SUMMARY MEMORANDUM

TO: El Paso County Planning Commissioners
FROM: Planning & Community Development
DATE: 4/6/2023
RE: SKP-22-005, Jaynes Sketch Plan, N.E.S. Inc.

JAYNES PROPERTY SKETCH PLAN

LETTER OF INTENT MEMO

**2**  
2 OF 4  
SKP225

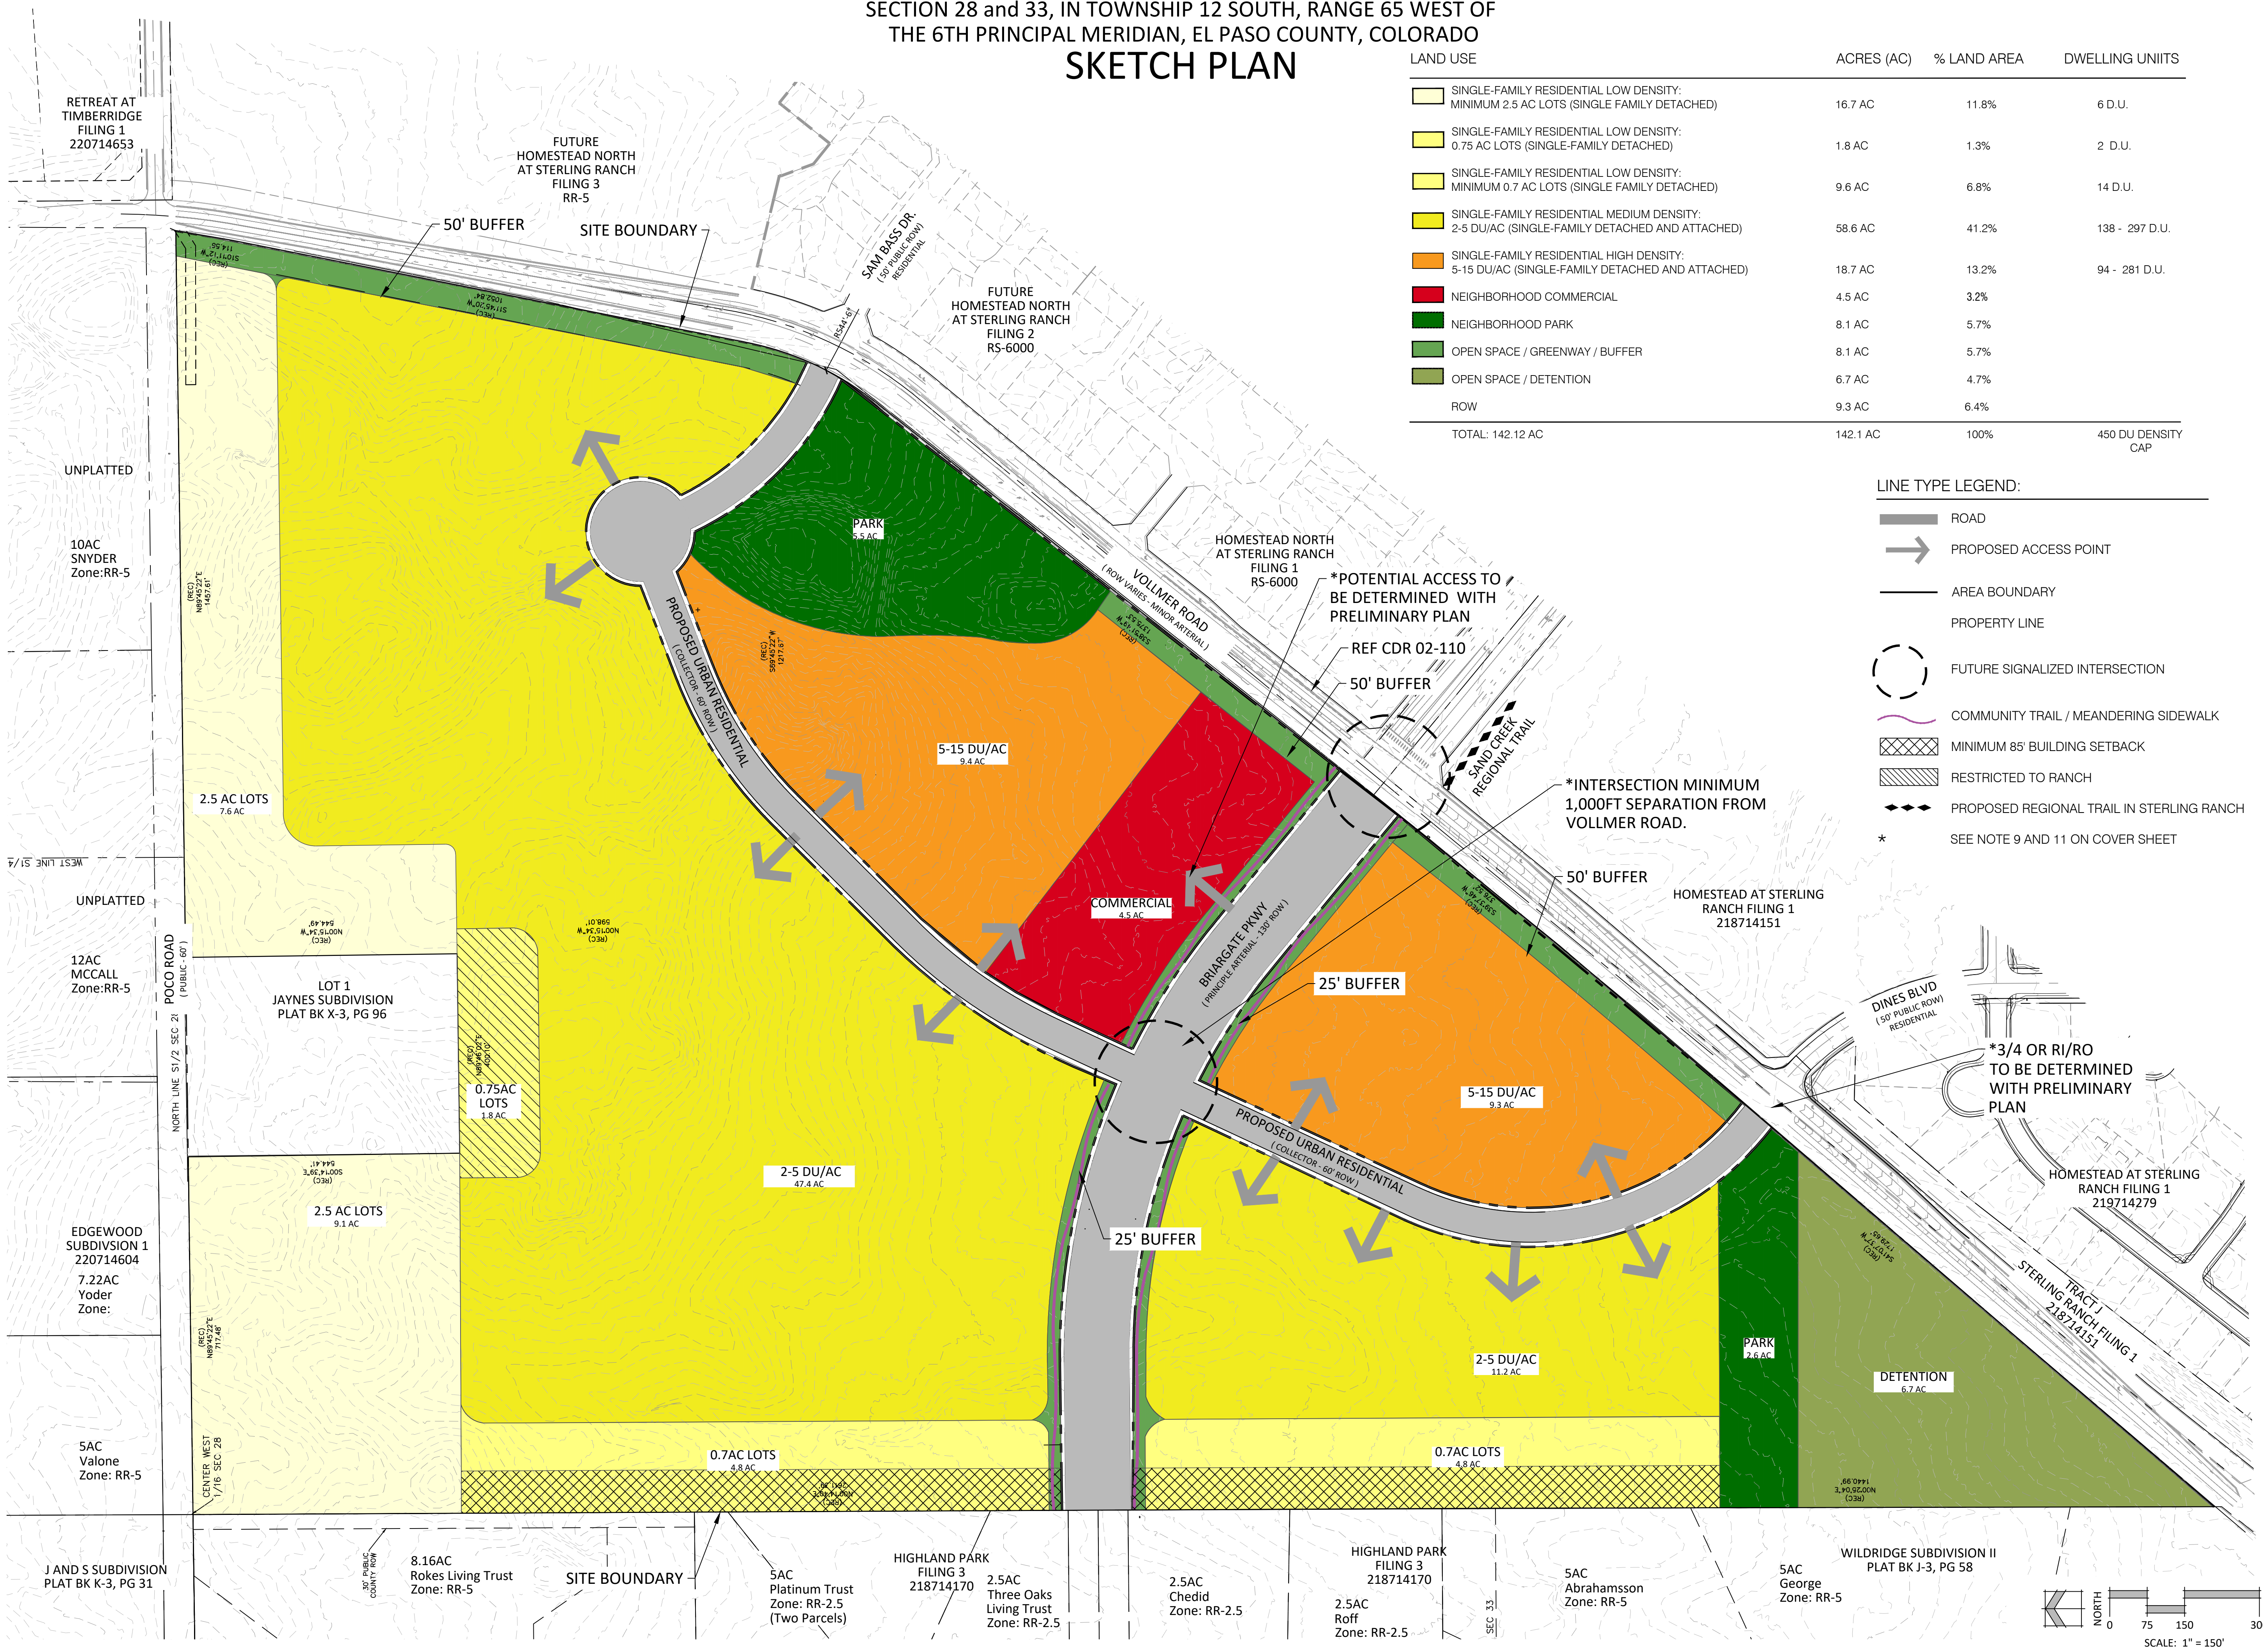
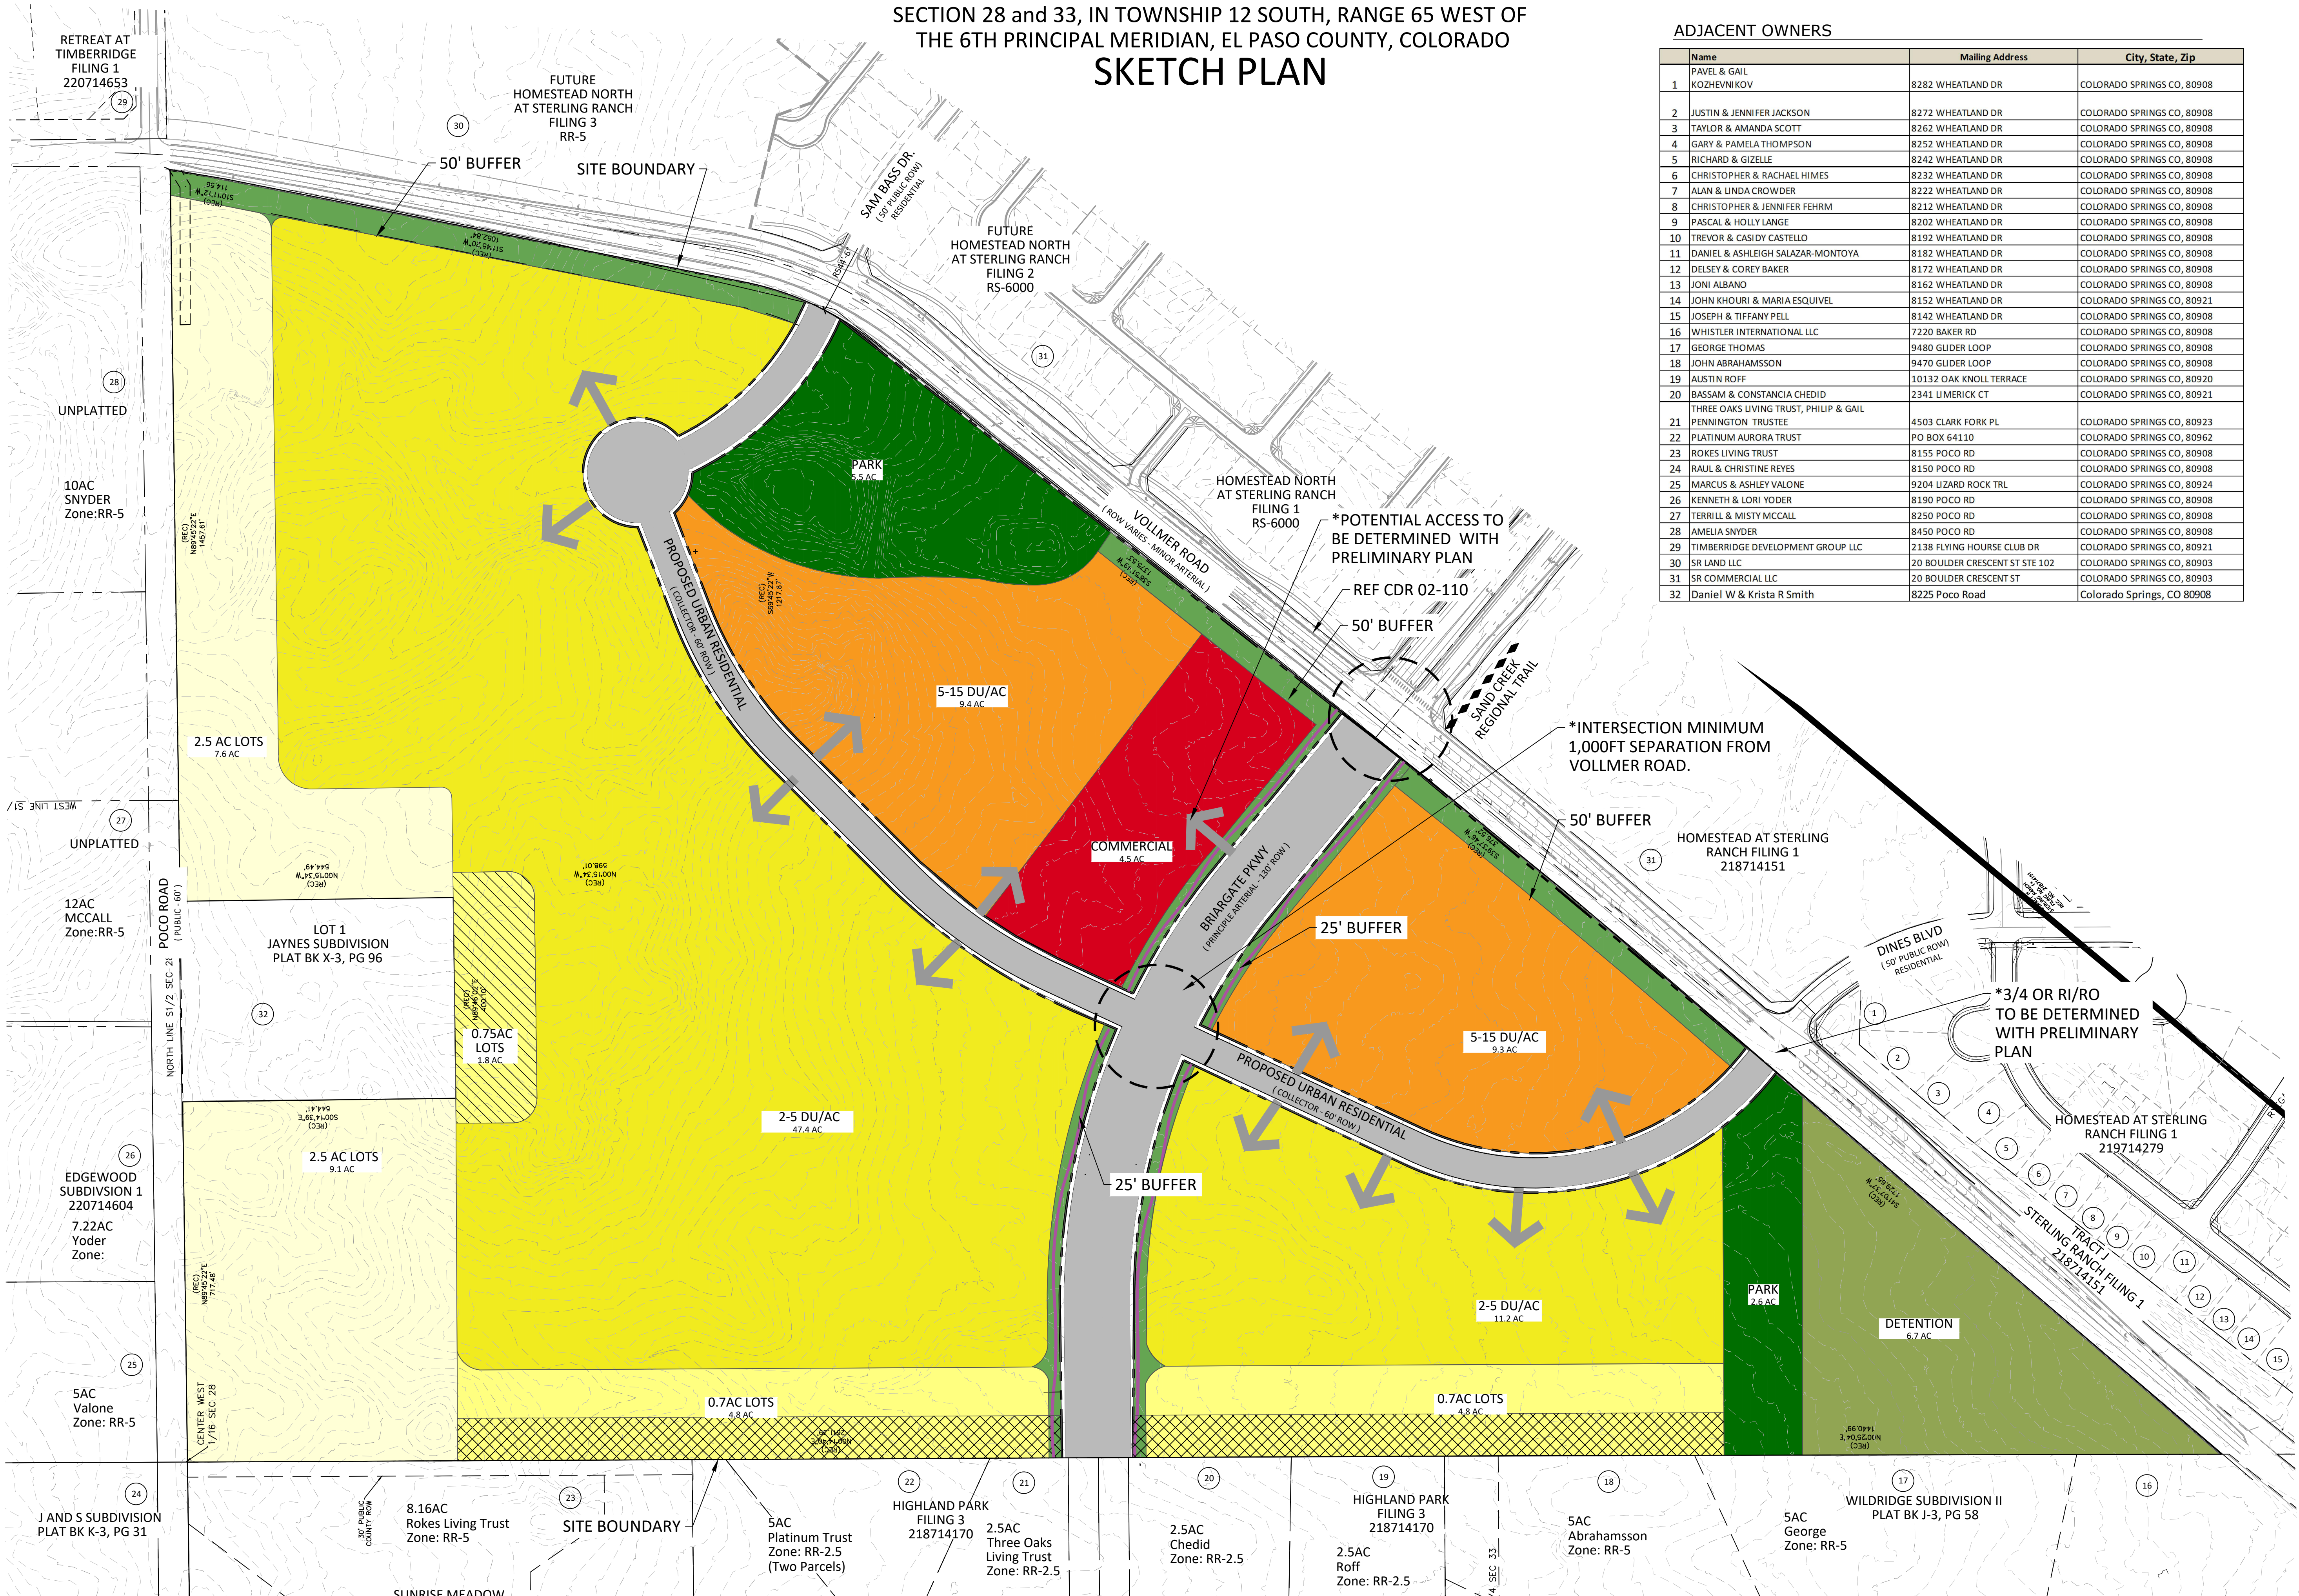
Jaynes Property Sketch Plan is amended to reflect comments received on 02/16/23 at the Planning Commission Hearing, relating to density transition from the existing rural residential lots to the north and west. Based on these comments, the following changes were made:

- Revision of 1AC lots along Poco Road to 2.5AC lots
- Removal of the 35' building setback along Poco
- Orientation of 2.5AC lots to match depth of the Smith Parcel
- Removal of the 50' buffer and 35' building setback around the Smith Lot
- Removal of the 50' buffer and trail along the west boundary
- Modification from 0.5AC lots along western boundary to 0.7AC lots with a 75' building setback by incorporating the 50' buffer into the lots.
- Increase in density interior to the site:
 - 5-12DU/AC has been changed to 5-15DU/AC

With these changes the max density of the sketch plan is below the 630 units analyzed with the traffic study. The density cap remains at 450 dwelling units. We believe that these changes will address the concerns related to density transitions while fulfilling the El Paso County Master Plan vision of Suburban Residential Development in the area.
